**From:** [REDACTED]  
**To:** [Planning Uploads](#)  
**Subject:** FW: Planning Discharge of Conditions Consultation - DOC/23/00682 - Astle House Astle Park West Bromwich B70 8NS  
**Date:** 21 November 2023 16:13:51  
**Importance:** High

This relates to discharge of conditions 22 and 24 of planning permission DC/12/55442 and conditions 20 and 22 of planning permission DC/12/55443.

The second of these - DC/12/55443 - is a listed building consent

Rear Elevation (Retail Park)

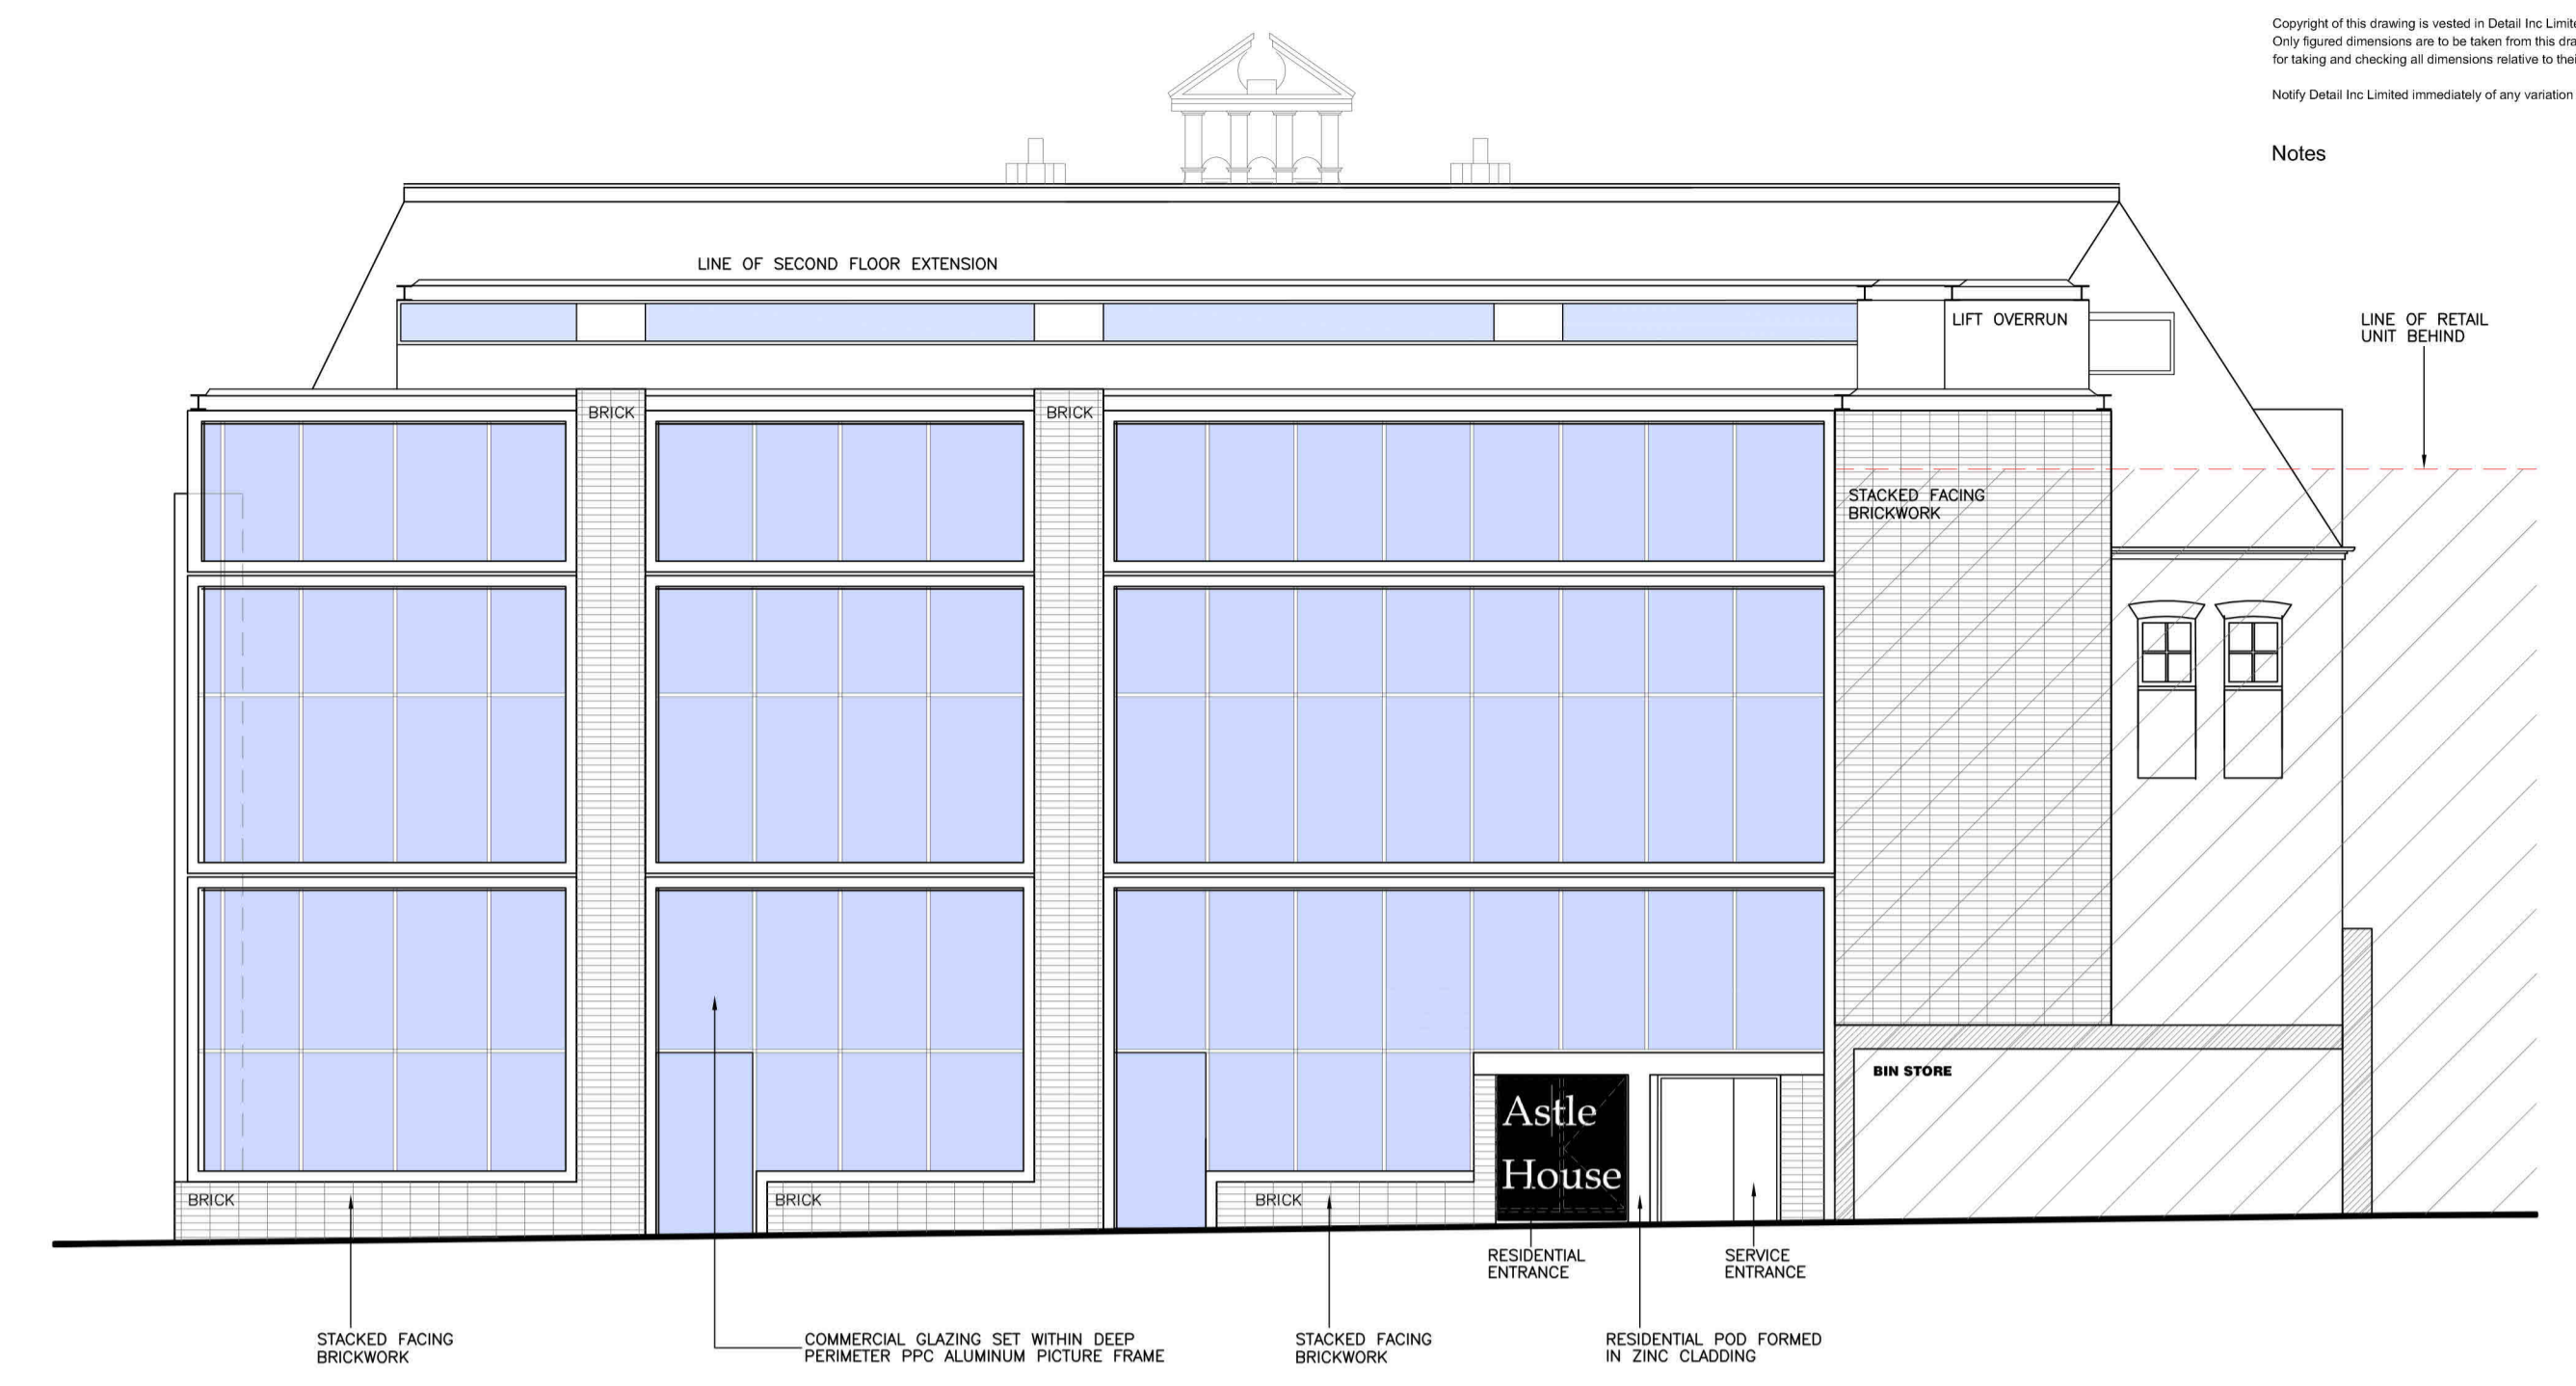
Condition 22 reads "Before the development is commenced details of the solar gain to the rear elevation highlighted within the Design and Access Statement for offsetting 10% of residual energy demand of the development on completion shall be submitted in writing and approved by the local planning authority."

I have no comment to make on residual energy – assuming the submitted details are acceptable in terms of the applicant's obligations under the terms of the T&CPA, I am happy for this to be discharged.

Side Elevation

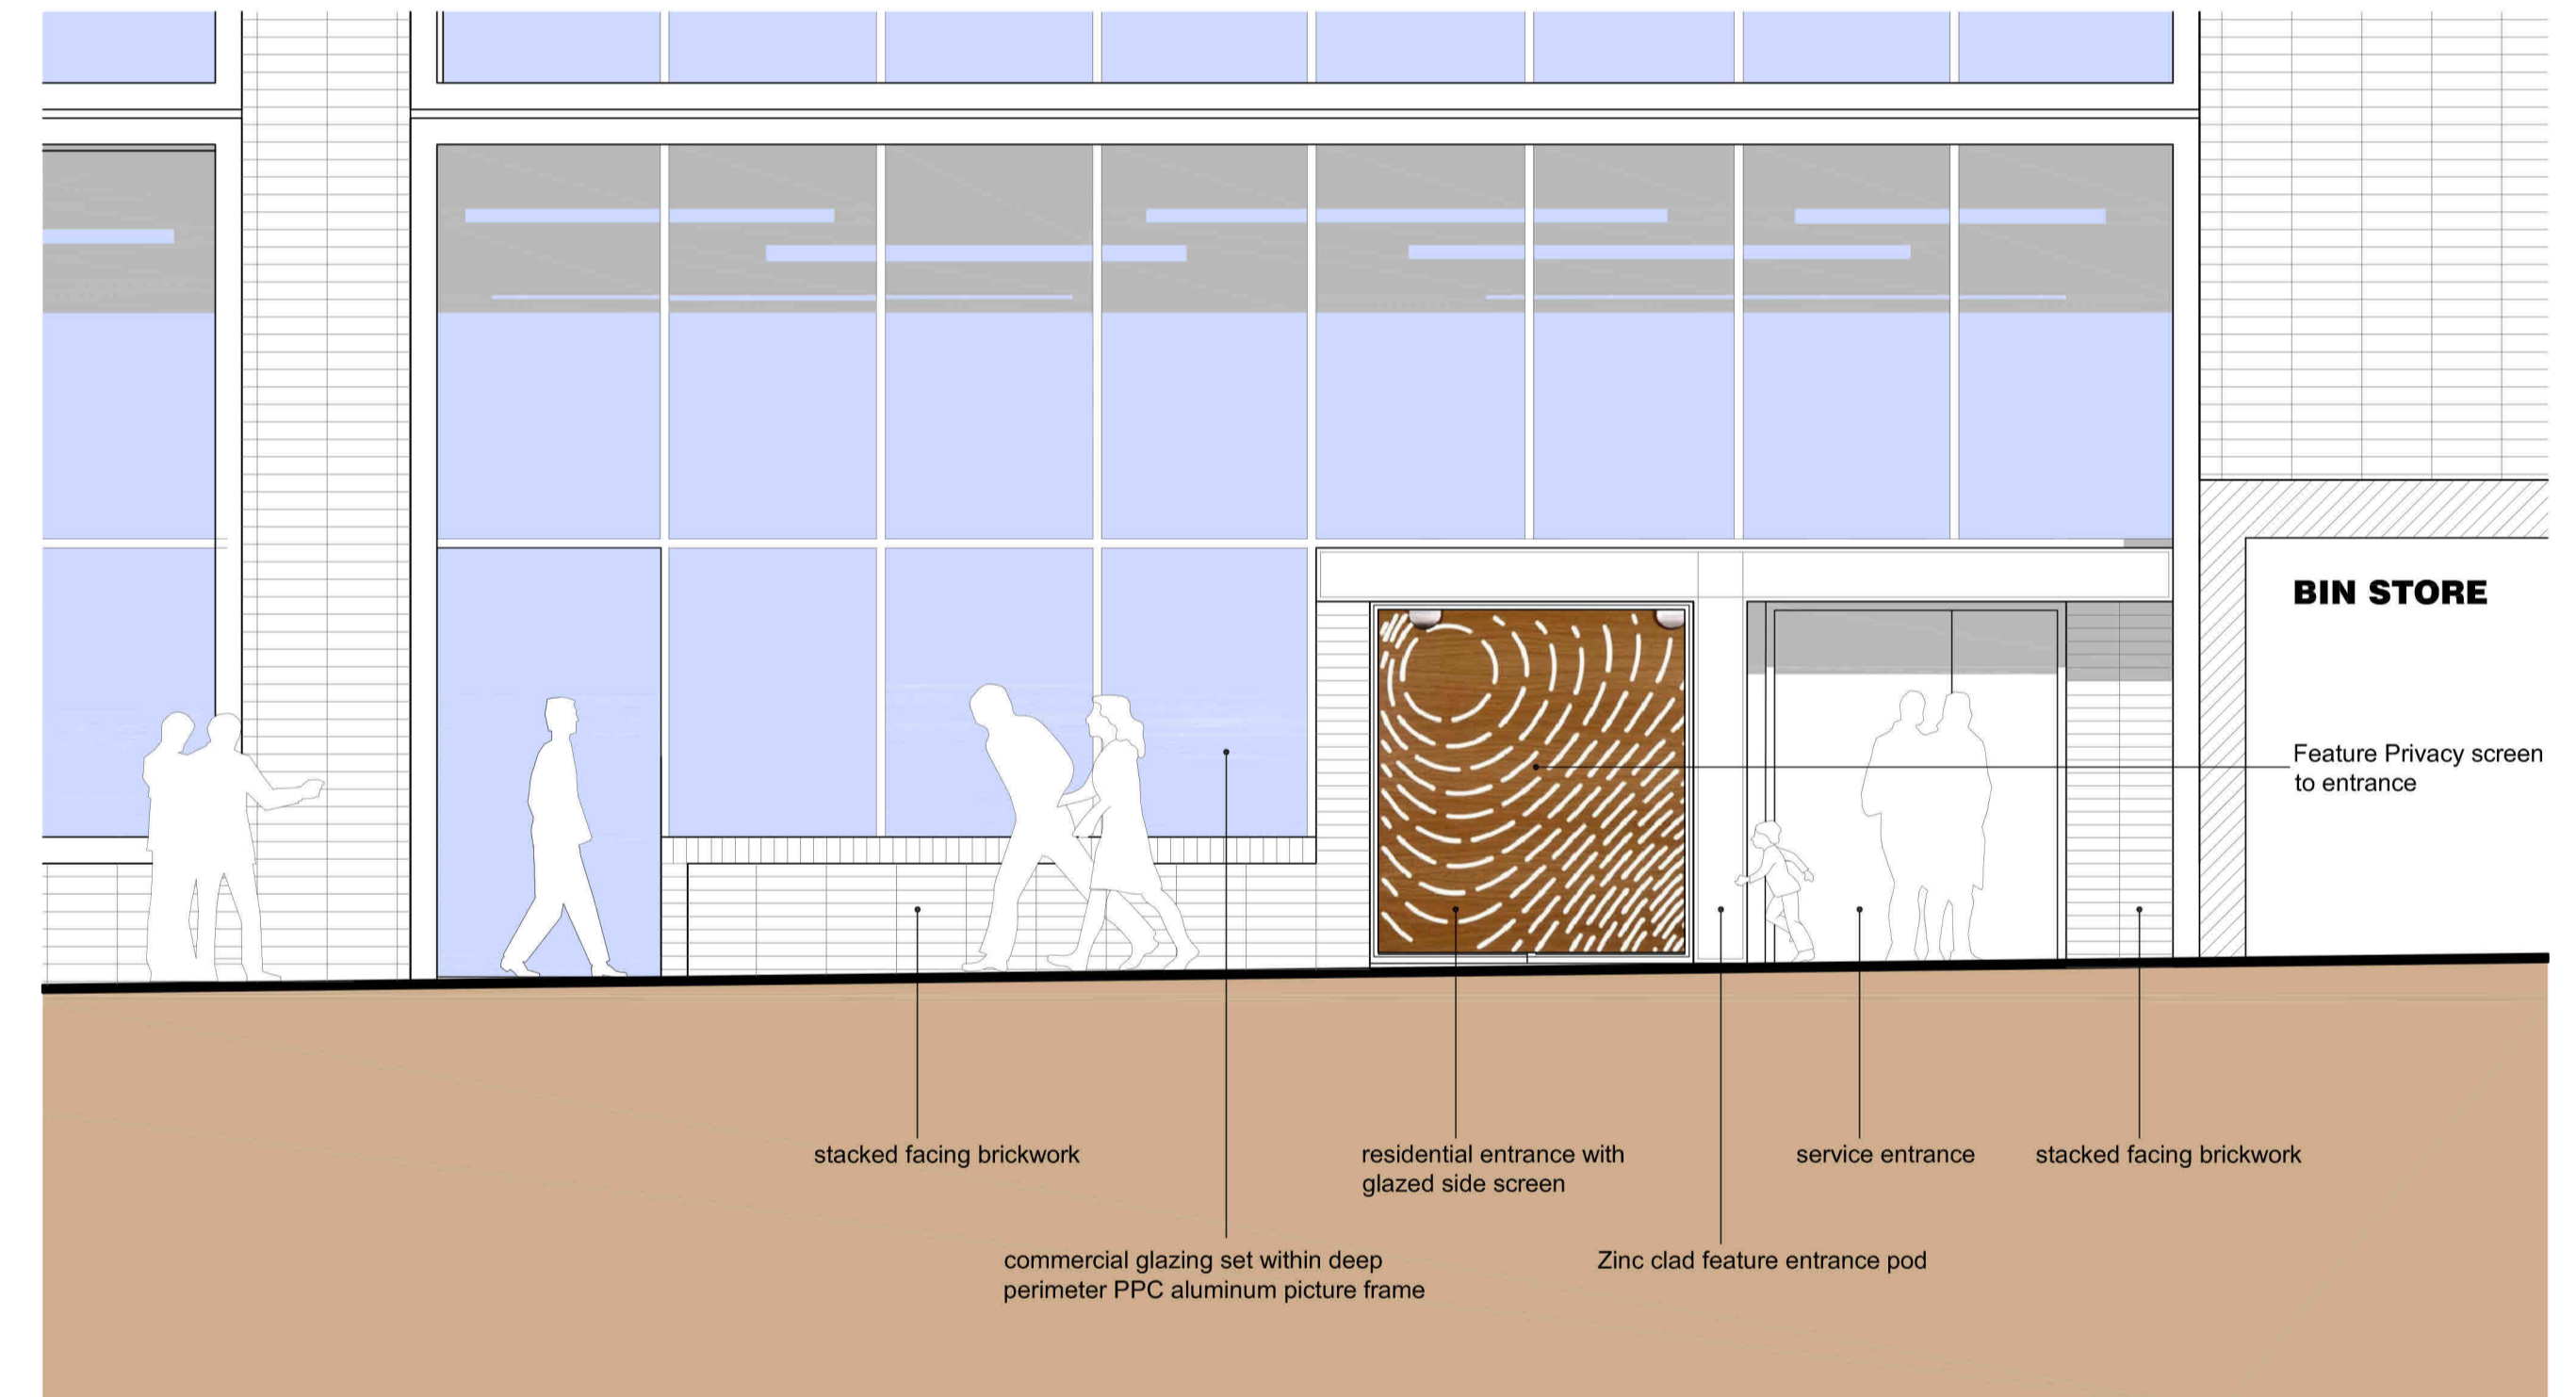
Condition 20 reads "The signage to the side elevation shall not be internally illuminated and before the development is brought into use details of the external canopy lighting to the signage on the side elevation shall be submitted in writing and approved by the local planning authority."

The details submitted show external canopy lighting, which, in my opinion, is acceptable.
